East Anglia ONE North and East Anglia TWO Offshore Windfarms

Applicants' Comments on Suffolk Energy Action Solutions' Deadline 6 Submissions

Document Reference: ExA.AS-27.D8.V1

Date: 25th March 2021

| | 5 | 09/09/2019 | AB | Fifth Issue. | | | 1:2,500 | <div><div></div>Metres</div> <div>050100200</div> |

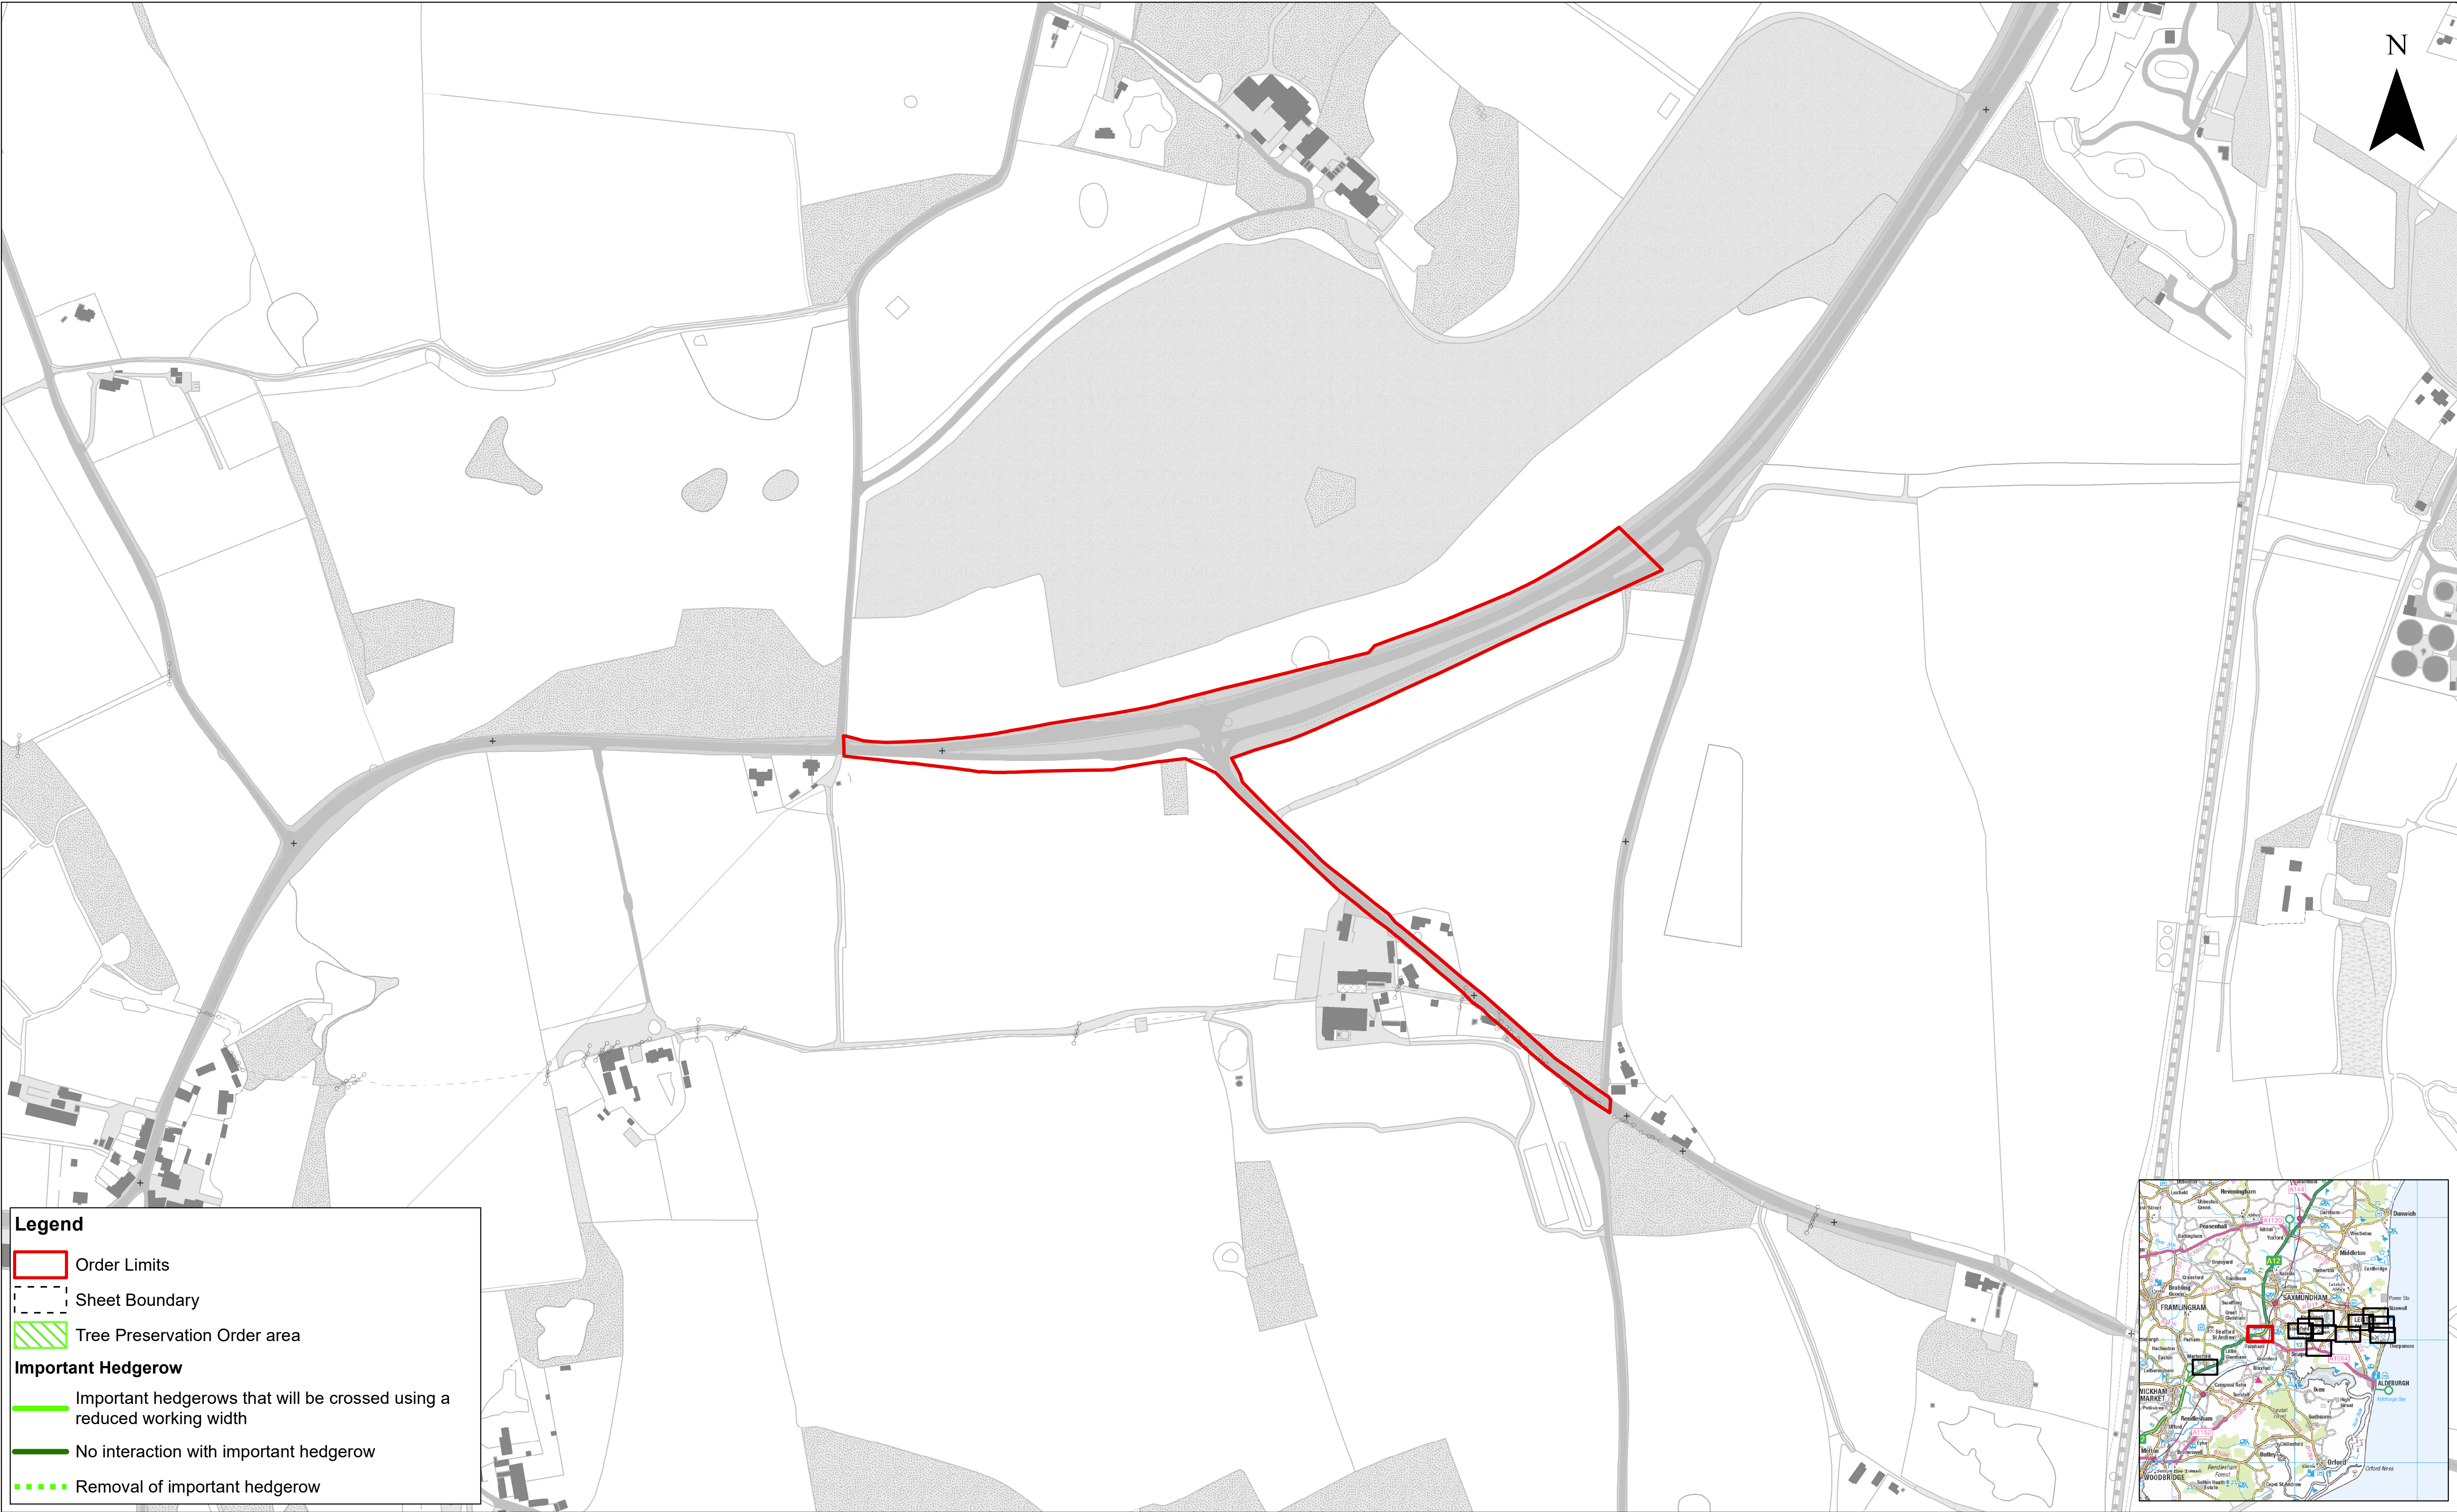
ID	SEAS' Comments	Applicants' Comments
45	6.10 Both hedges will have to be removed.	The Applicants note that the length of hedgerow associated with Fitches Lane required for removal in this area is important hedgerow marked 21 on sheet 5 of 12 of the Important Hedgerows and Tree Preservation Order Plan (REP3-010).
46	6.11 Fitches Lane and the paths through the wood are resources joining two villages, enabling children to walk to the Primary School, as well as offering places for children to play. Although there has been some development by the new owners in recent years (one owner's child has a bike track in an area of the wood), we still hear our migrant birds return each spring. The construction will remove this resource and the Lane.	Noted. The Applicants note that a temporary diversion of the public right of way (PRoW) E-260/007/0 (from the western end of Fitches Lane towards Coldfair Green) will be required during construction. This temporary diversion will be implemented in accordance with the final Public Rights of Way Strategy, which must accord with the Outline Public Rights of Way Strategy (REP3-024) and be approved by the relevant planning authority prior to undertaking works that would affect the PRoW, pursuant to Requirement 32 of the draft DCO (document reference 3.1). Pursuant to Article 11 of the draft DCO , temporary PRoW diversions must be provided to the standard defined in the Outline Public Rights of Way Strategy (REP3-024), to the satisfaction of the relevant highway authority, prior to the stopping up of the existing PRoW.
